Dear Ms. McGuire:

I'm writing to provide additional input on Mercer Island Permit Application 2207-019's recent [submission response memo](#) (SUB2) and corresponding revised [plans](#). On October 25, 2022, I and my attorney, Zach Davison, submitted comments during the public comment period on the initial plan set. This letter supplements those comments in response to the revised plans submitted by the applicant on March 1, 2023.

BUILDING ELEVATIONS

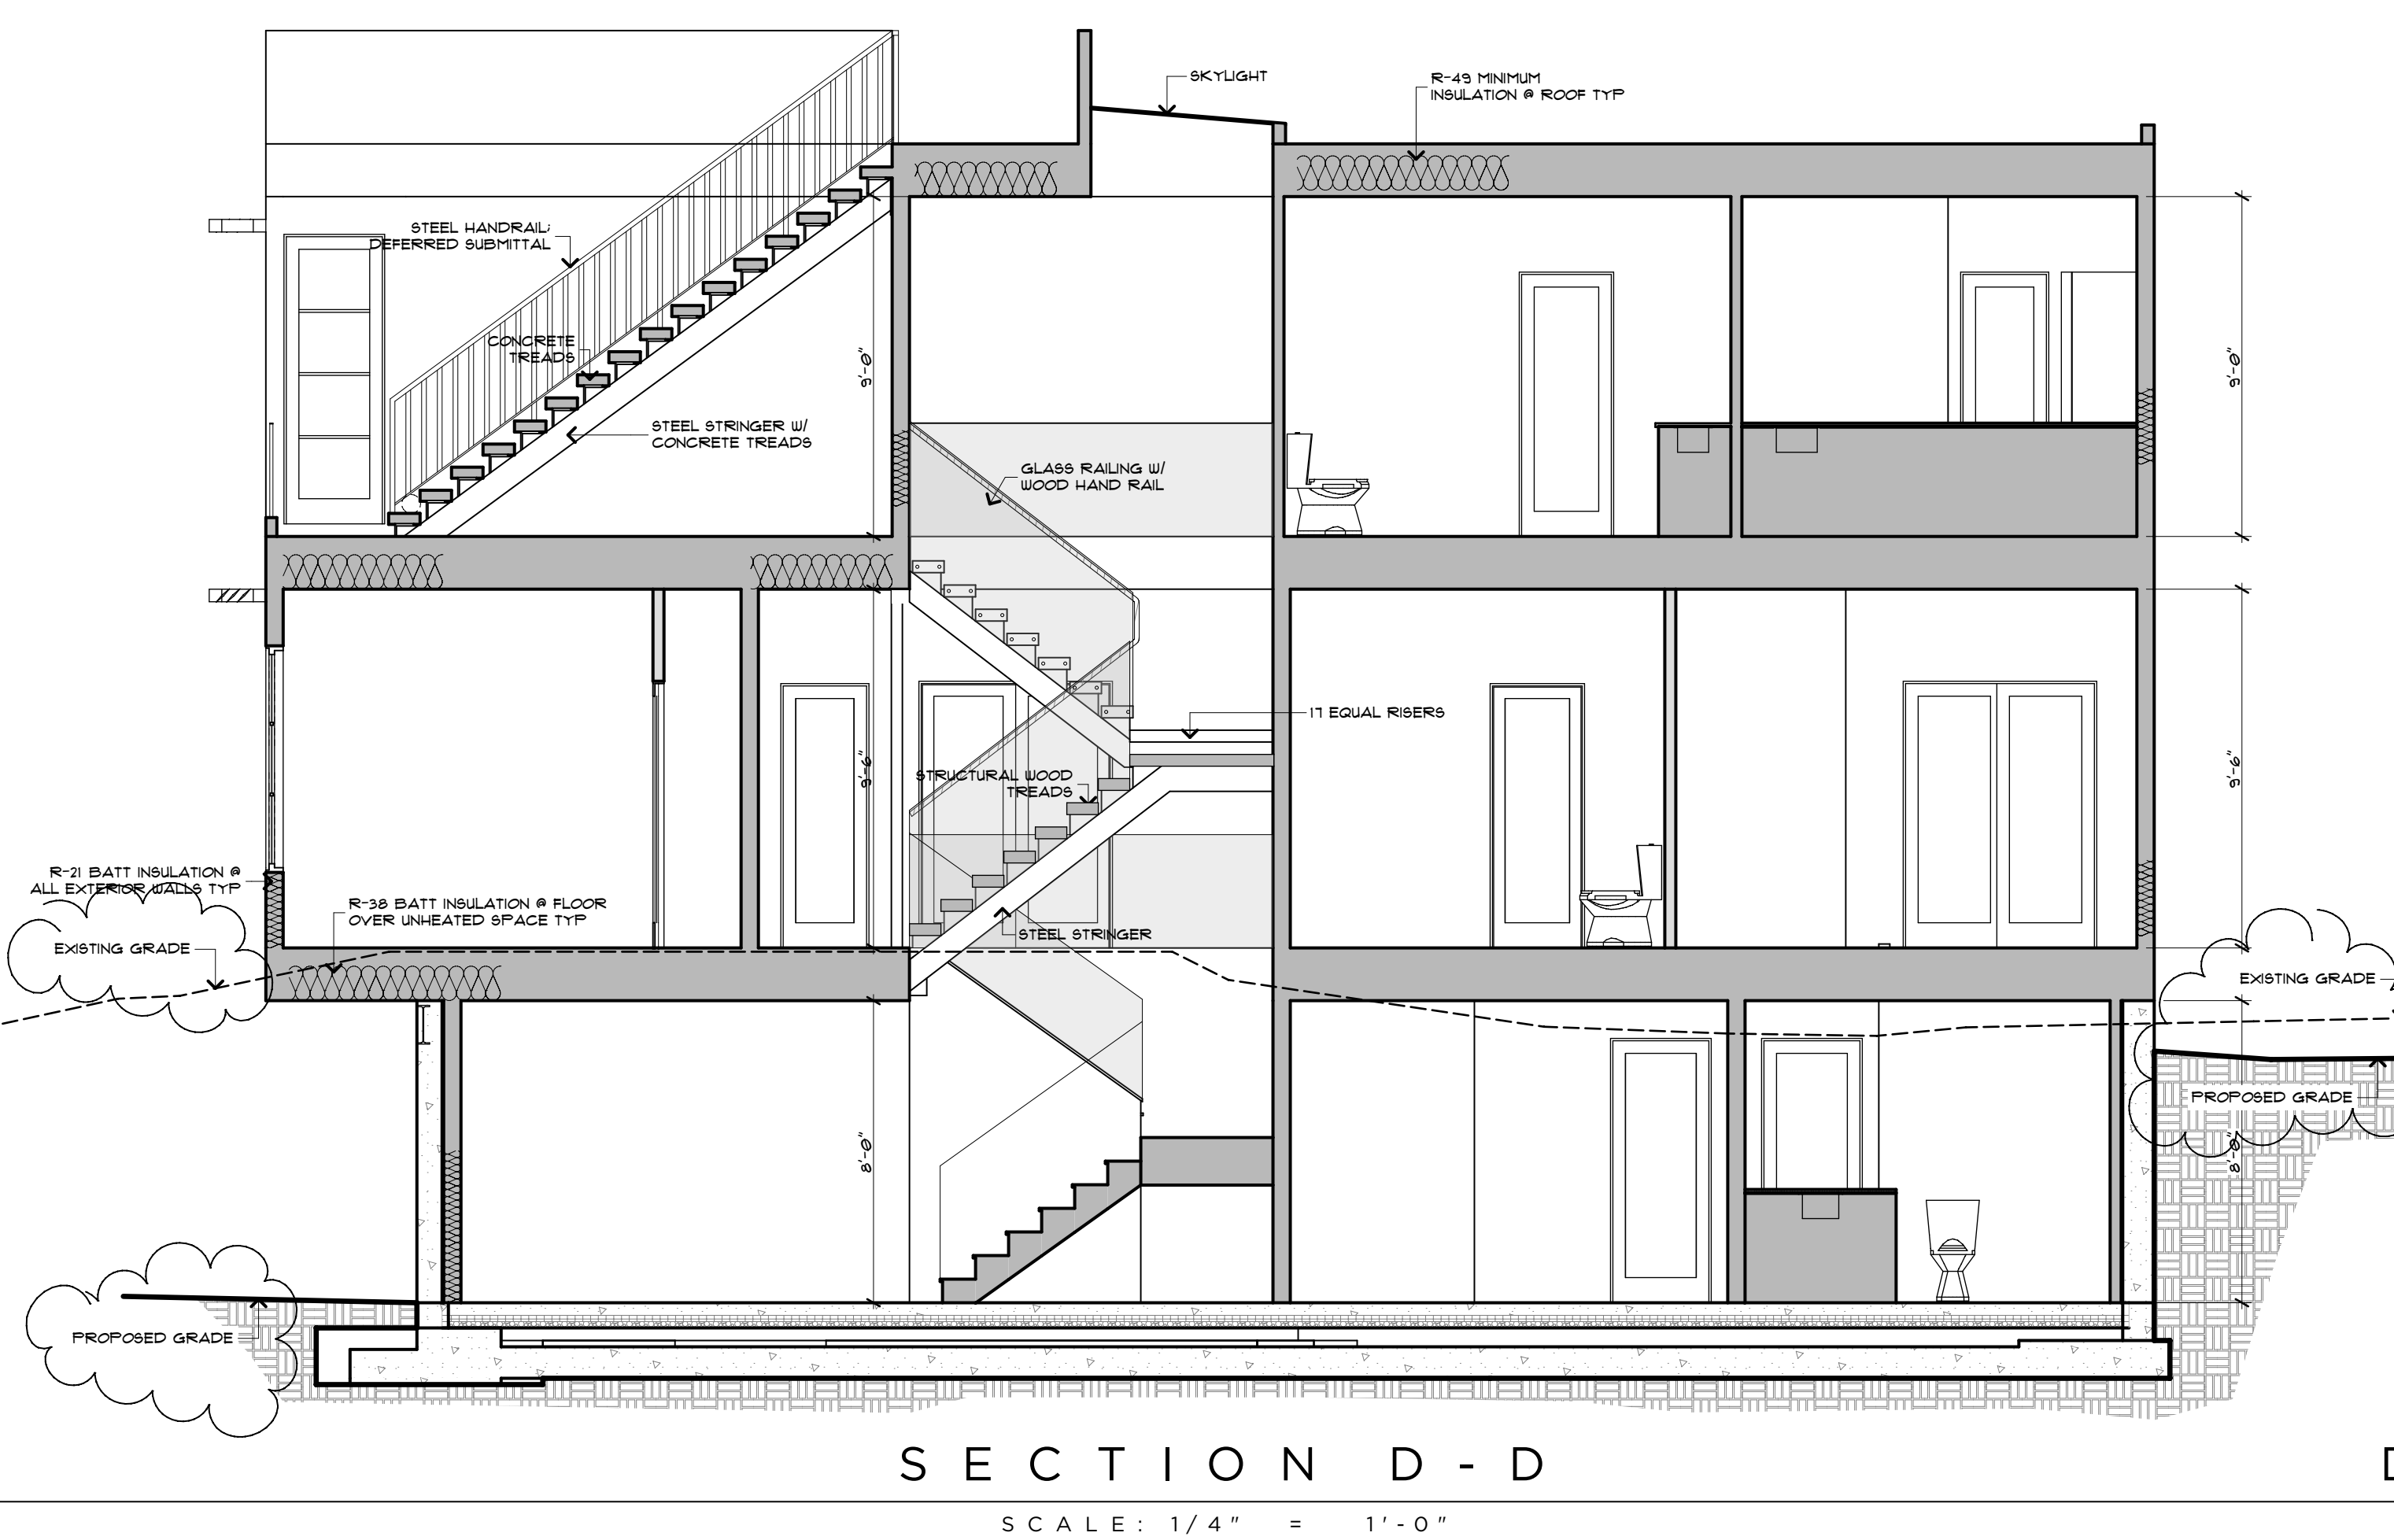
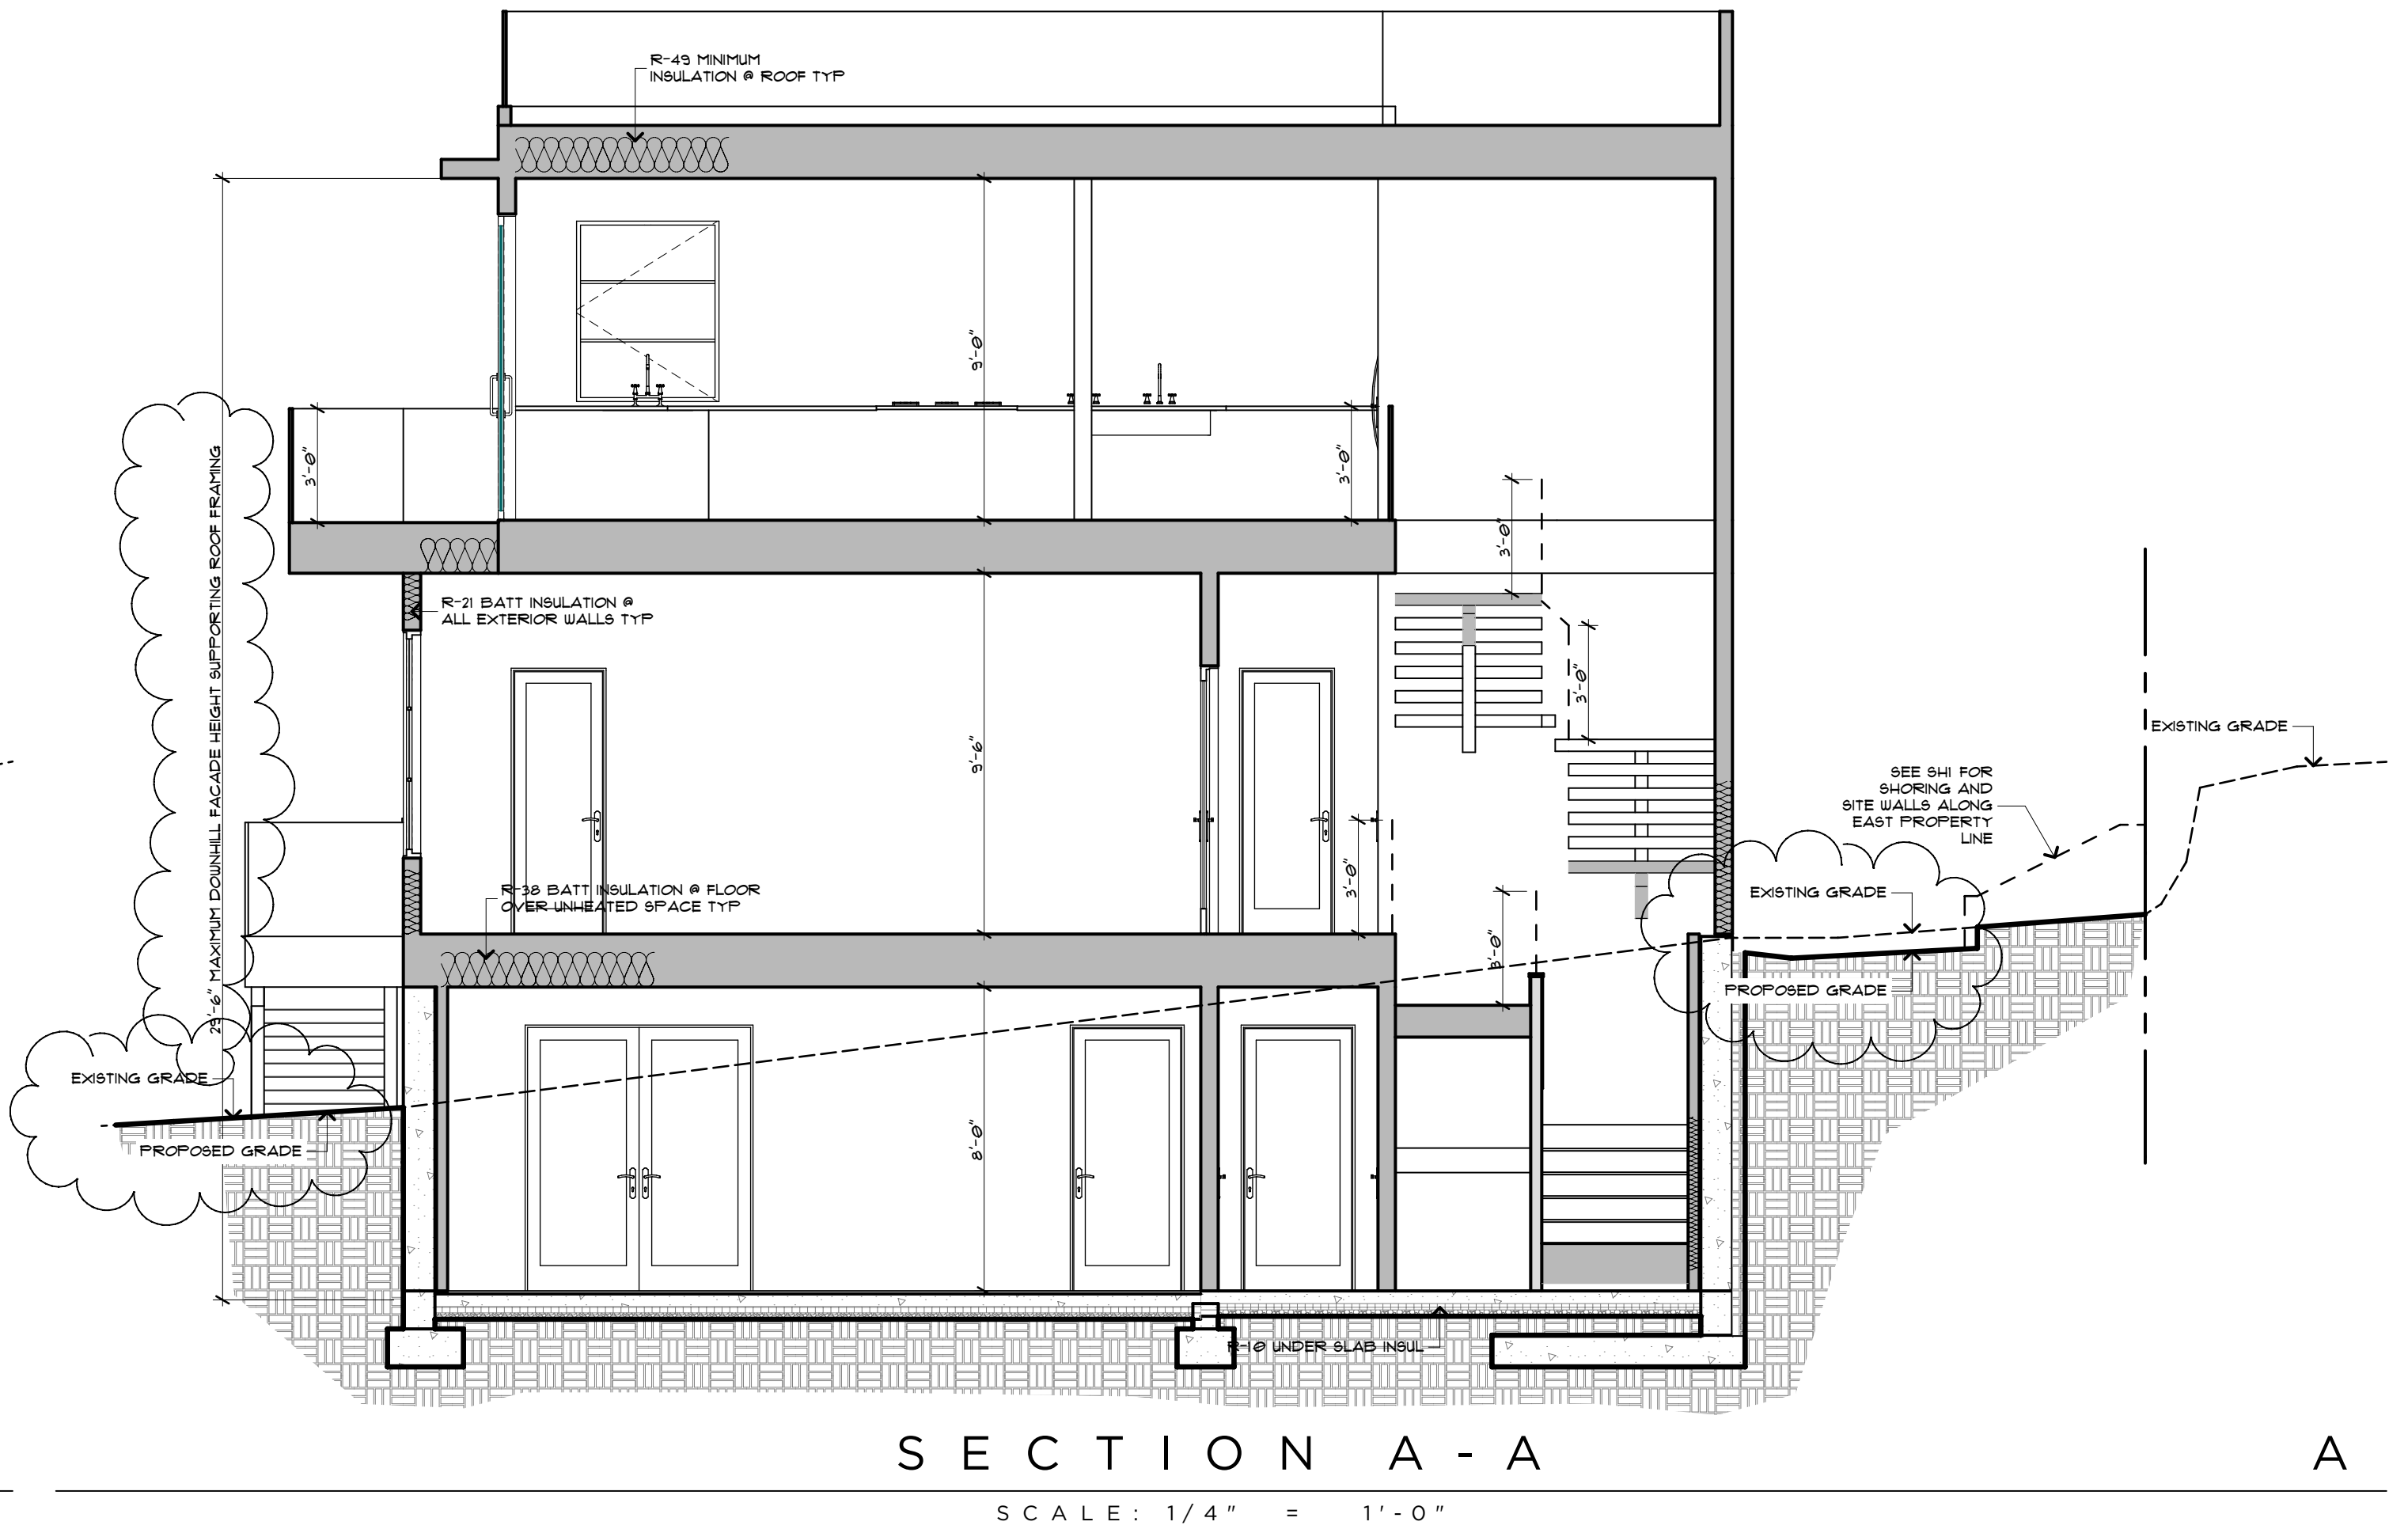
- West elevation:
 - Covered wall surface at Finished Grade shown in gray, uncovered in red. this shows coverage of ~33% based only on Finished Grade. Precise computation requires clear elevations for the ground floor ceiling and Level 1 FF, which are unavailable.
 - Existing Grade is incorrect, as shown earlier.
 - 2021 Grade appears to be correct.
 - Coverage is incorrectly computed.

North Elevation:

- Finished Grade appears correct.
- Existing Grade is incorrect, as shown earlier.
- 2021 Grade does not match SUB2. The blue area below shows the actual exposed wall in 2021, because part of this wall sits on top of an existing basement.
- Coverage is incorrectly computed.

East Elevation:

- Finished Grade appears correct.
- Existing Grade is incorrect, as shown earlier.
- 2021 Grade does not match SUB2. The blue area below shows the actual exposed wall in 2021, because part of this wall sits on top of an existing basement.

South Elevation:

- Finished Grade appears to be correctly computed.
- Existing Grade is incorrect, as shown earlier.
- 2021 Grade appears to be correct.
- Coverage is correctly computed as 0%.

4. Maximum Building Height on Downhill Façade is shown on the South Elevation of the updated drawings and is measured at 29'-6" to the top of the wall supporting the roof framing per MICC

SUB2 incorrectly excludes the deck railing and the area at the top of the wall from the Facade Height.

By not correctly using the Existing Grade (which is lower than the Finished Grade), the height of Facade is further incorrectly computed.

SUB2 also violates MICC 19.2.020.C.1.c.iii - "Single-family dwellings with a height of more than 25 feet measured from the existing or finished grade, whichever is lower, to the top of the exterior wall facade adjoining the side yard shall provide a minimum side yard depth of ten feet."

The ">25" facade shown below is because SUB2 incorrectly computes the "lower of Existing Grade or Finished Grade" on the East side of the structure.

Note that the Southern elevation facade is a facade onto Side Yard 1 (Side Yard 1 has the facades from both the Eastern and Southern Elevations).
